Ribble Valley Borough Council
Church Walk,
Clitheroe,
BB7 2RA

Phone: 0300 123 6780
Email: lhscustomerservice@lancashire.gov.uk
Your ref:
Our ref: LHS/CS/03/2017/0171 and 0173
Date: 9th August 2016

Proposal:	Change of use of existing two storey rear extension from bed and breakfast guest rooms and cafe to form one new dwelling.
Location:	Dog and Partridge Tosside BD23 4SQ
Grid Ref:	376895 - 456092

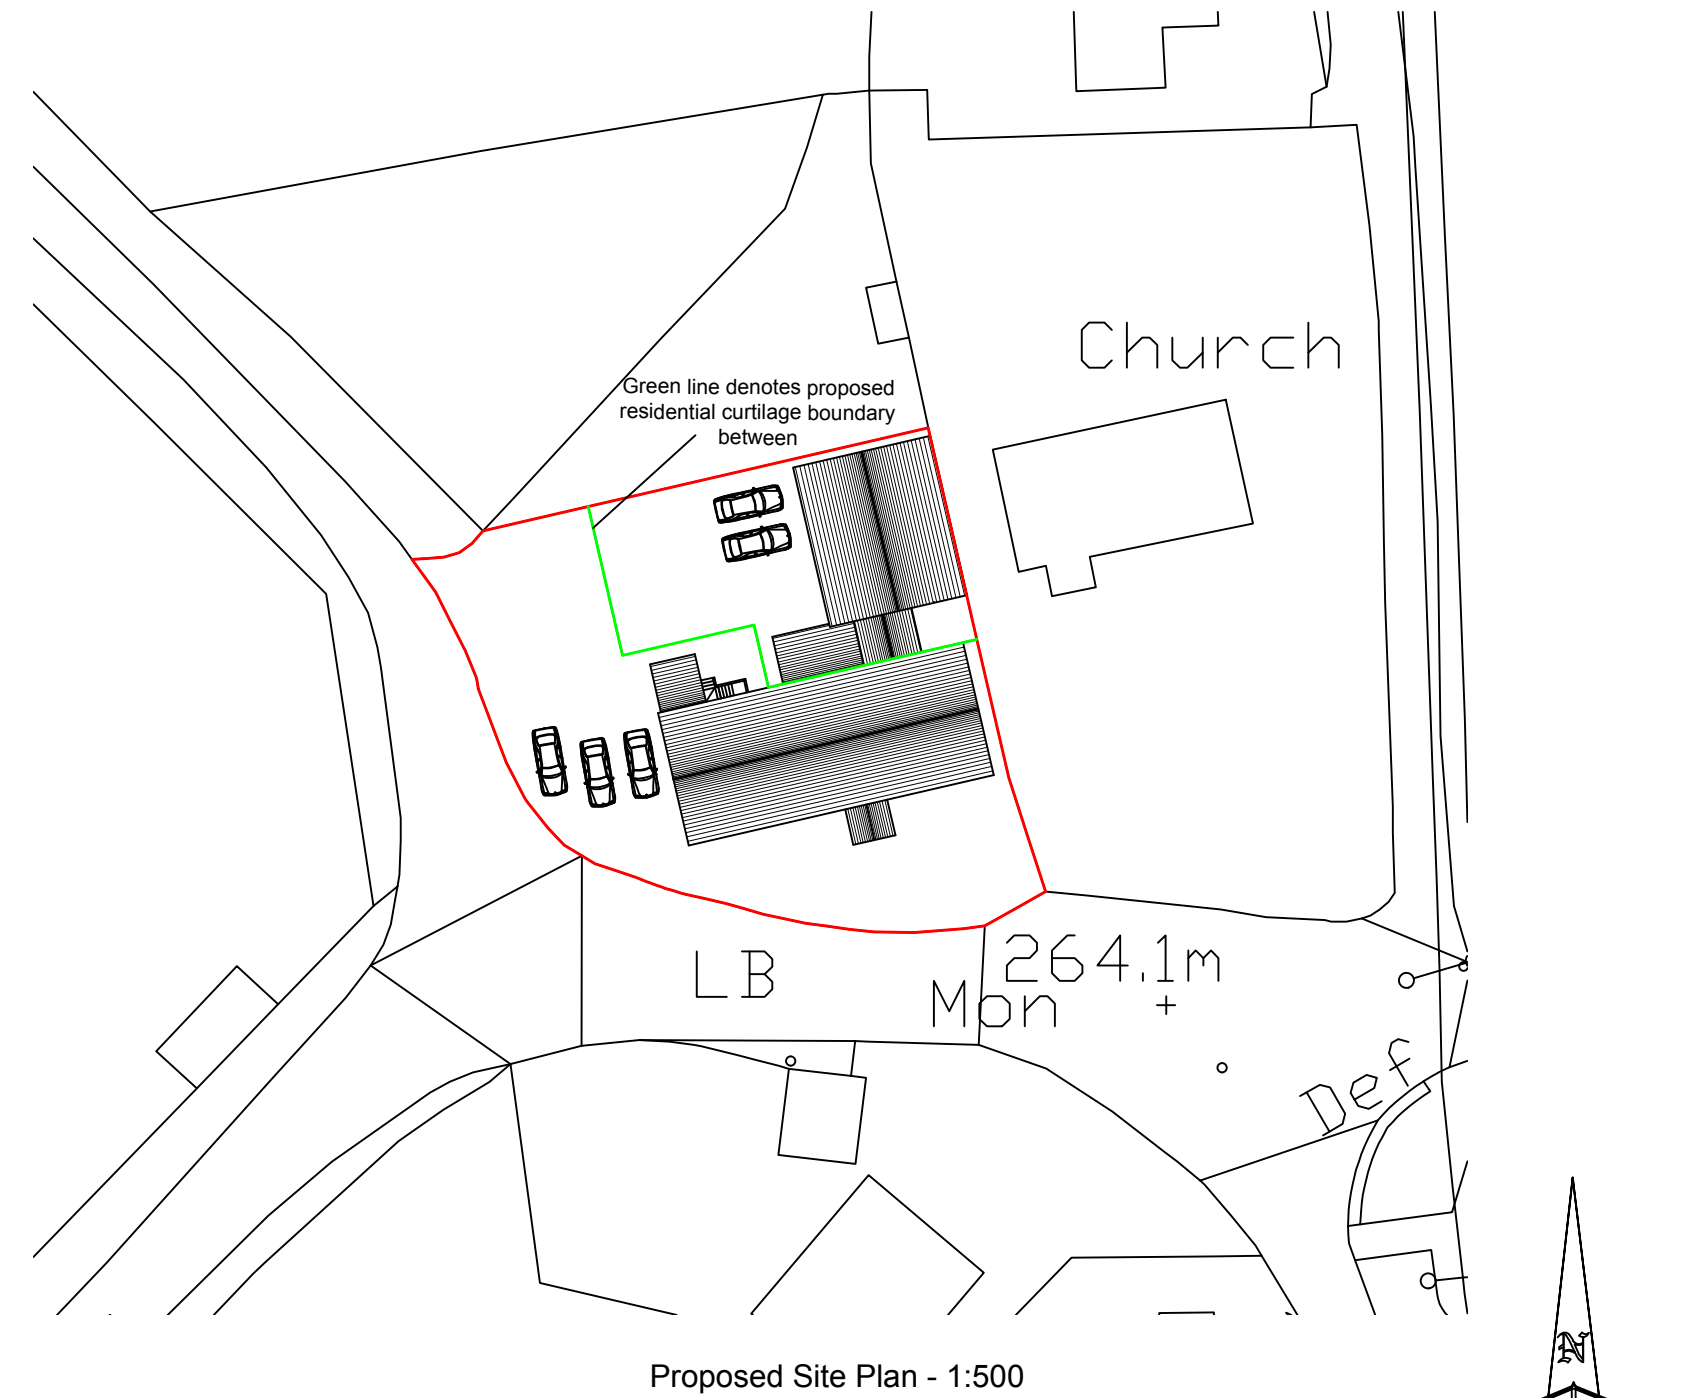
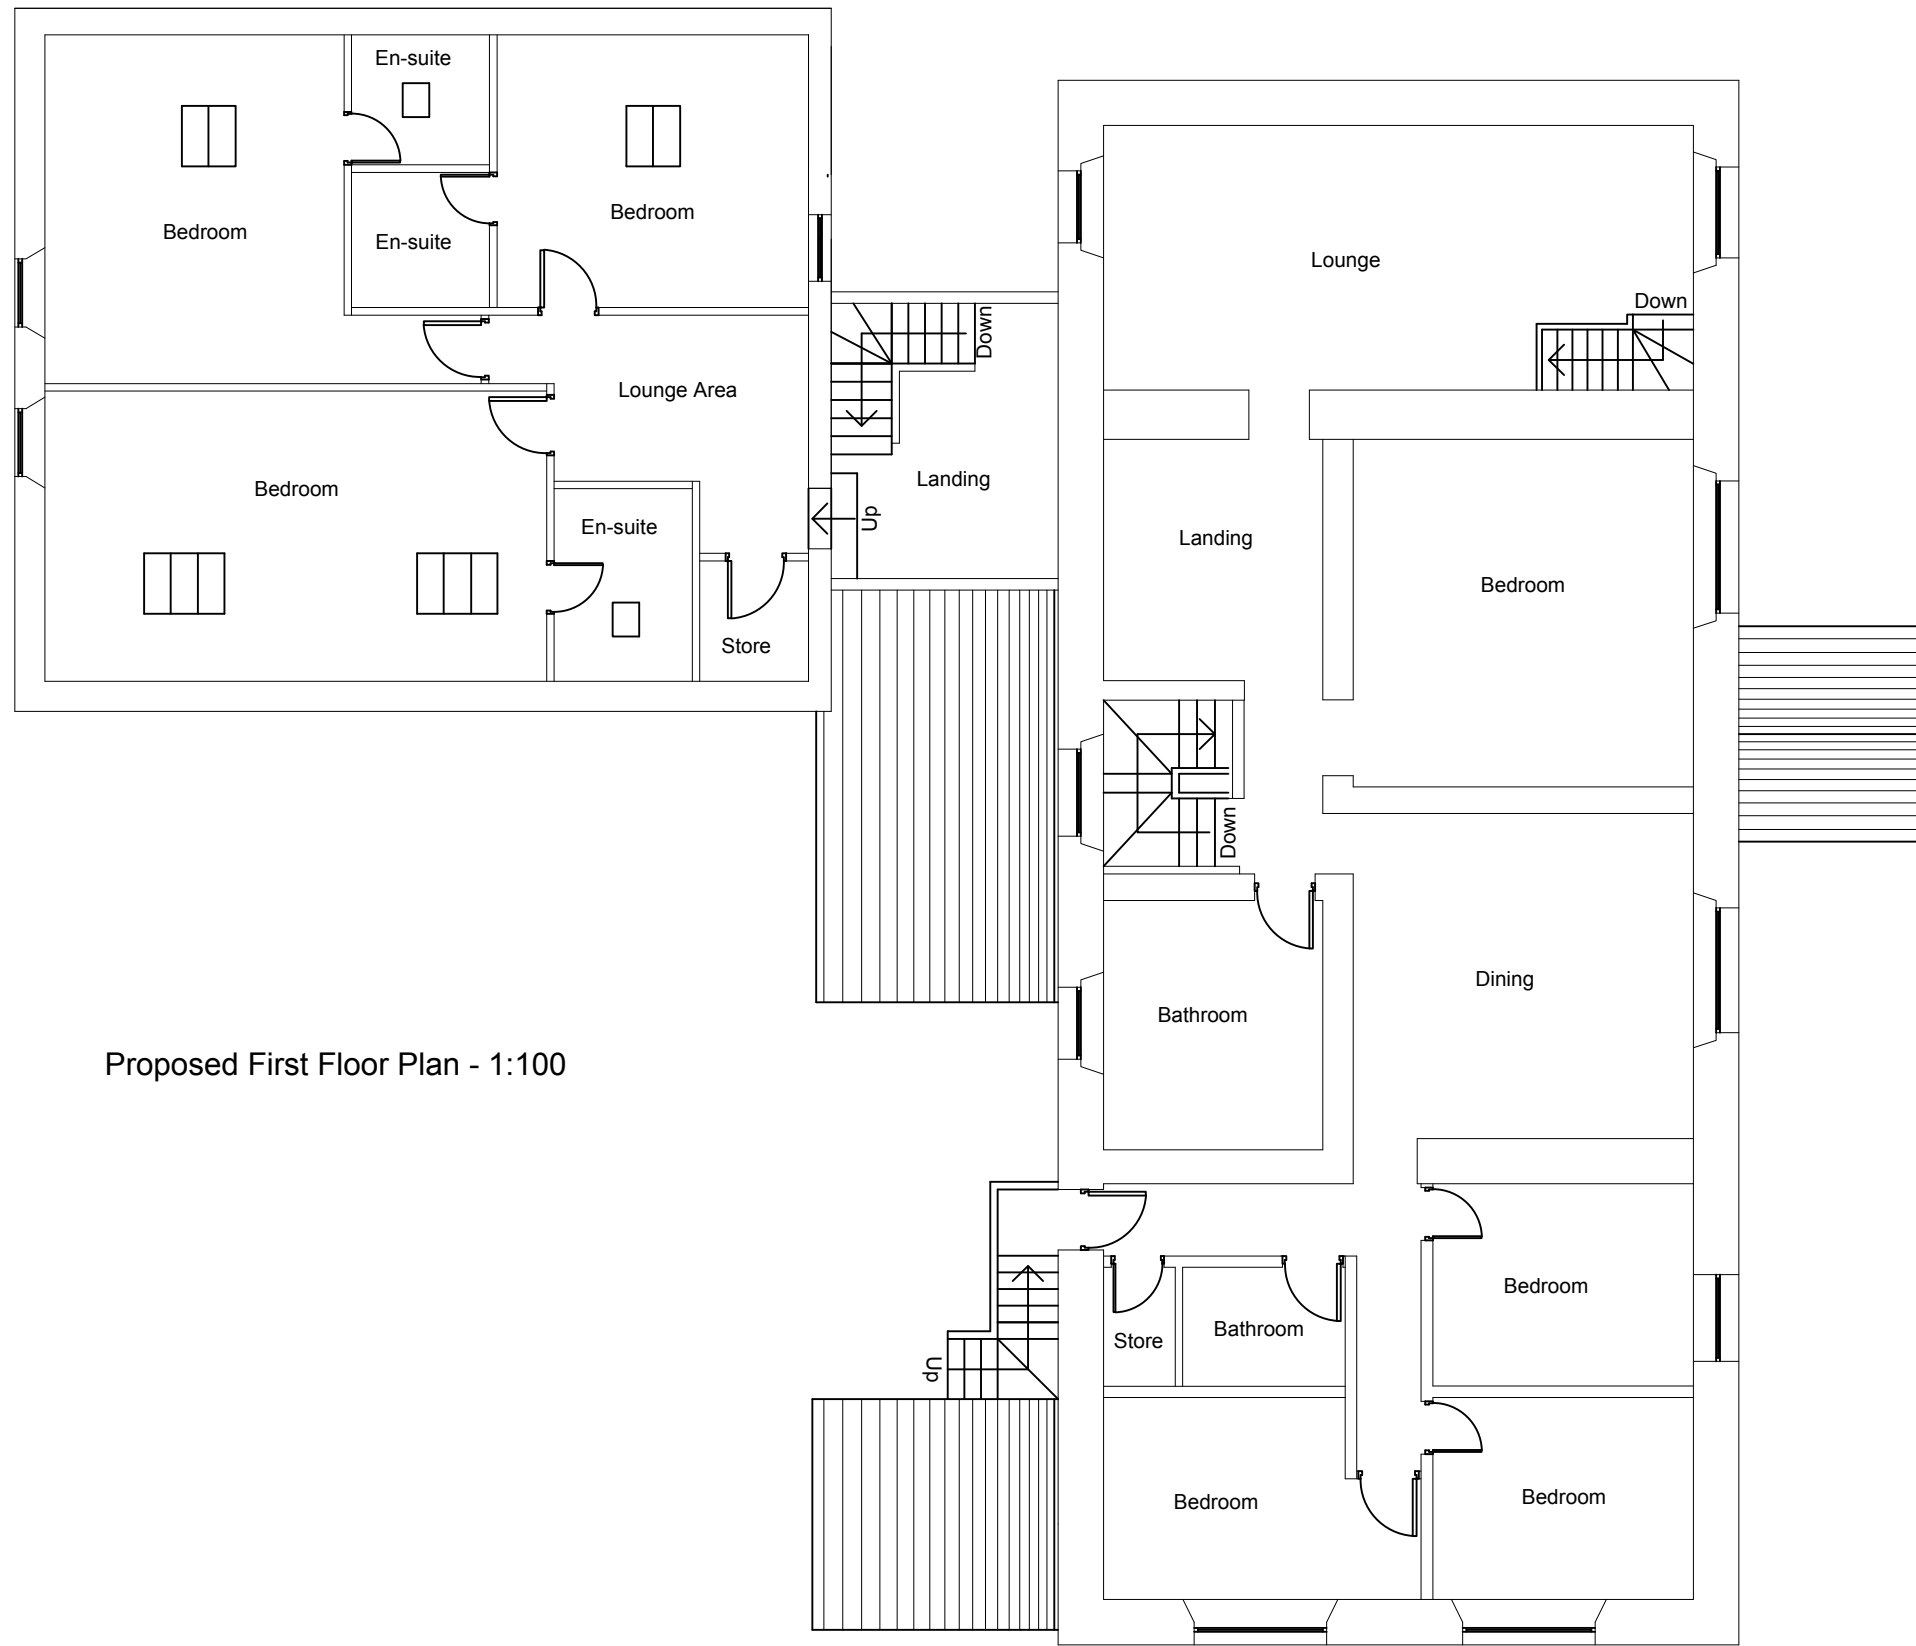
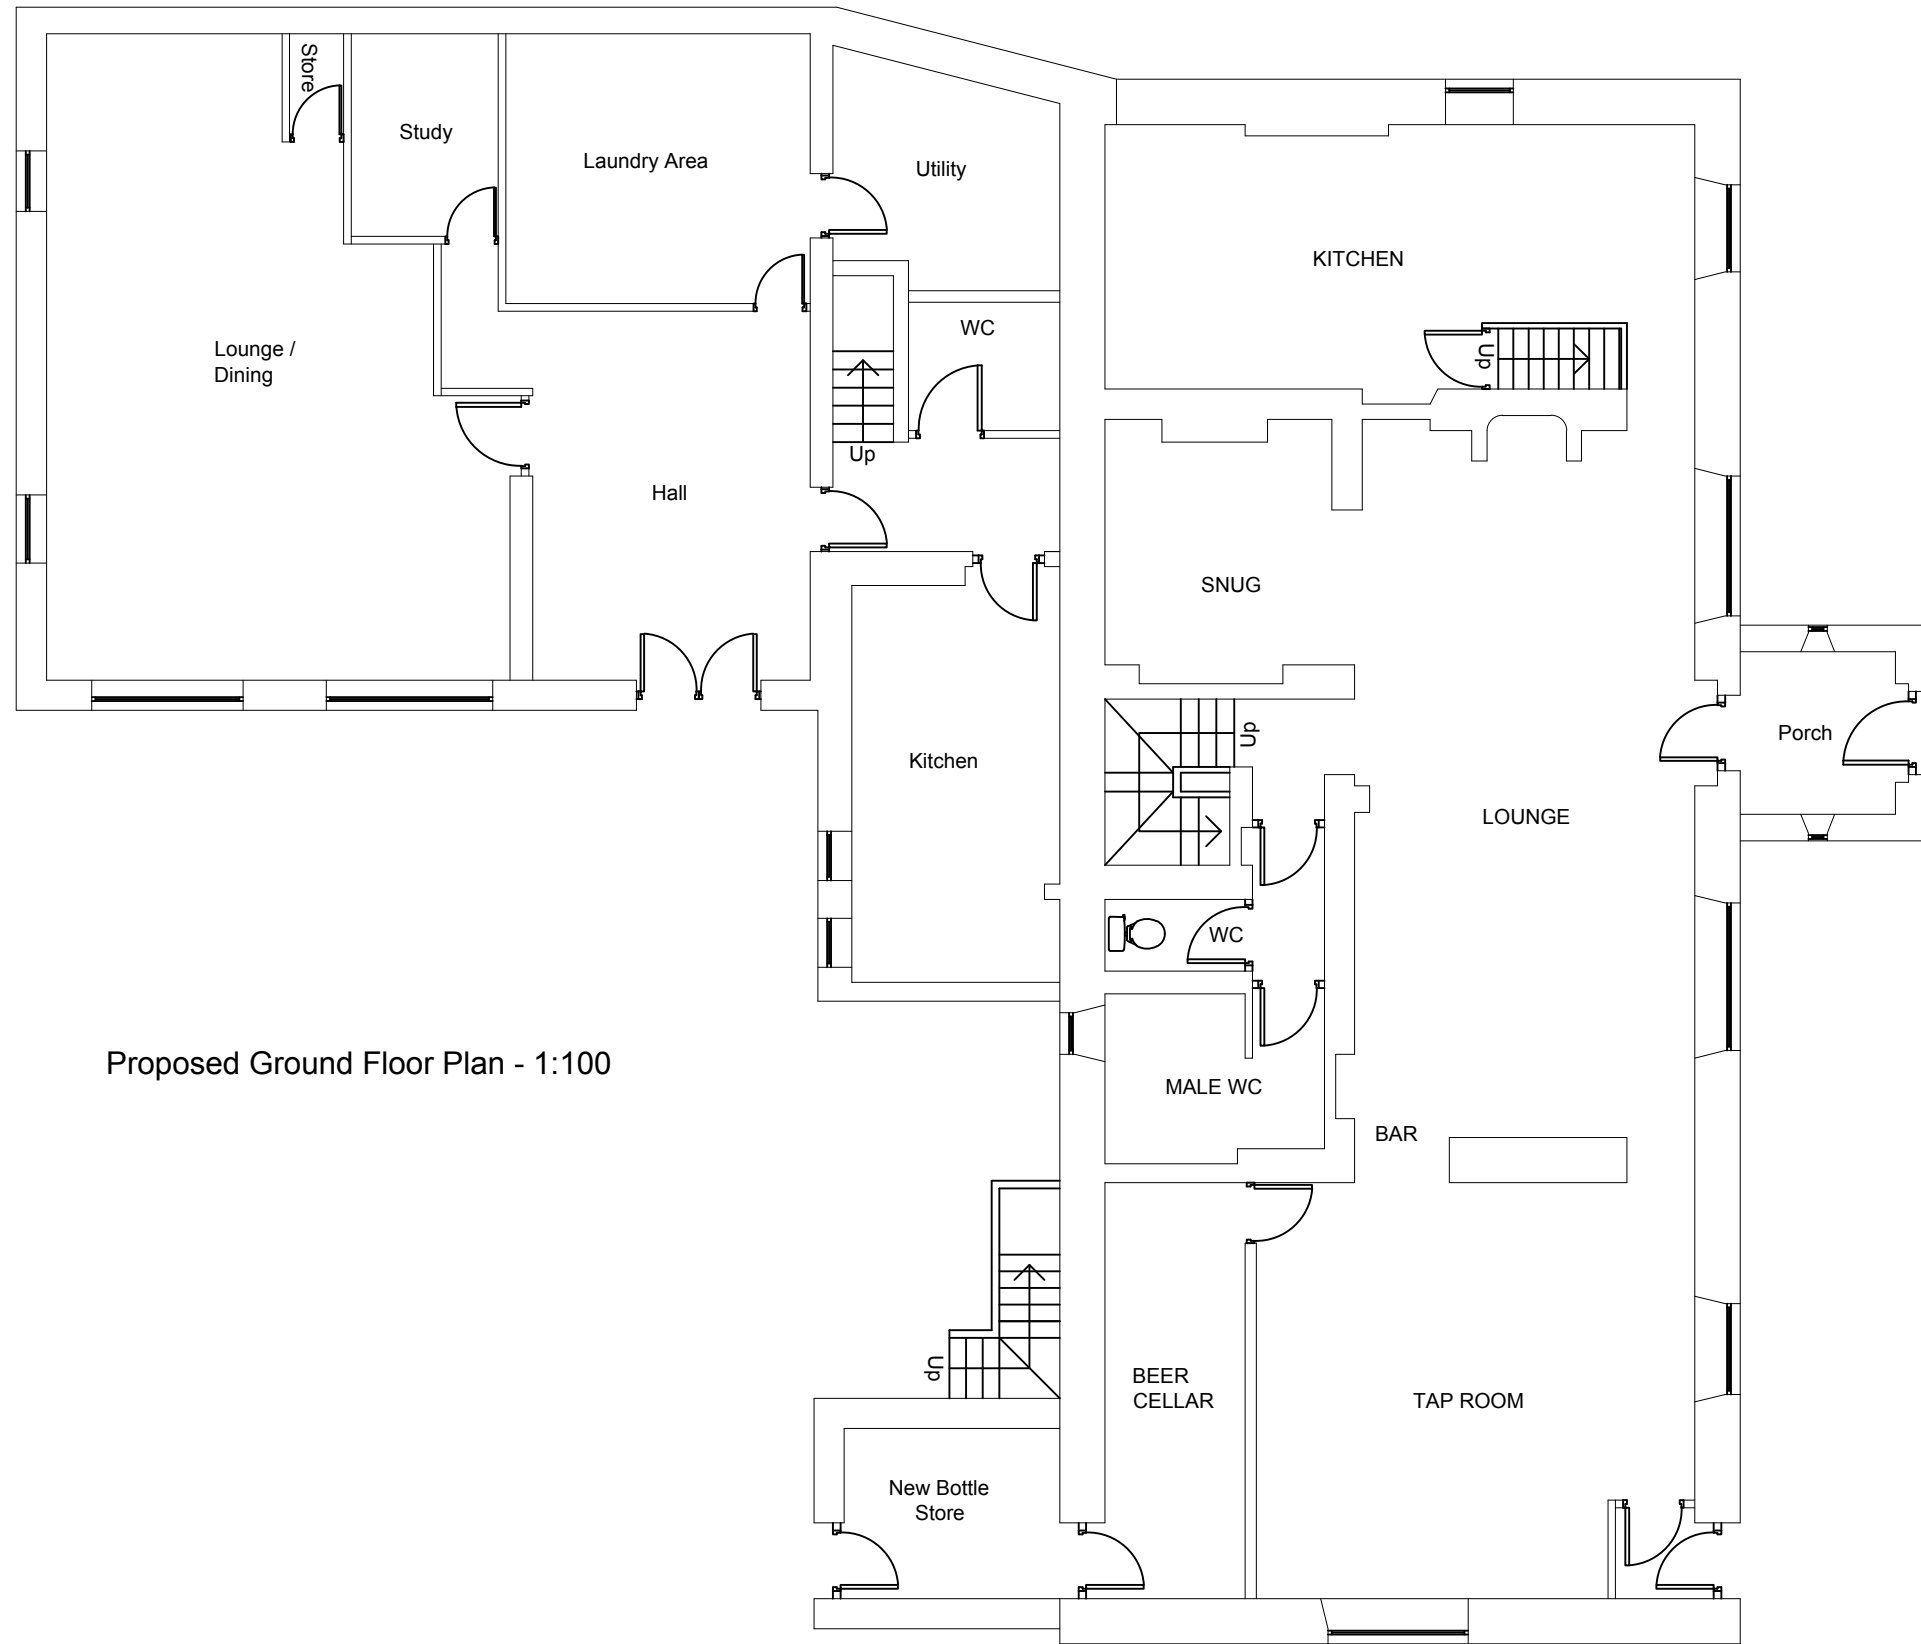
The Highway Development Control Section does not have any objections in principle to the proposed change of use providing the applicant can provide an acceptable level of off-road car parking for the remaining public house and owner's accommodation above.

Based on the car parking recommendations in the Joint Lancashire Structure Plan and the Ribble Valley Parking Standards, the Highway Development Control Section is of the opinion that the applicant should provide either one off-road car parking space for each 5sqm of public floor area for the public house or one off-road car parking space per 8sqm of the gross ground floor area.

The Highway Development Control Section is of the opinion that on road parking fronting the site would have a detrimental impact on highway safety by narrowing the available carriageway width, with no provisions for pedestrians needing to walk in the road to pass the parked vehicles. On-road parking would also prevent two way traffic movements at the detriment to highway and the obstruction of the sight lines from the Bailey Lane at the detriment to highway safety.

There is also a private access serving the properties opposite the site and on-road parked cars would affect the safe manoeuvring in and out of this drive.

The applicant is advised to provide an accurate survey of the floor areas as recommended above and then show the recommended number of parking spaces before determining the application, in the interest of highway safety.
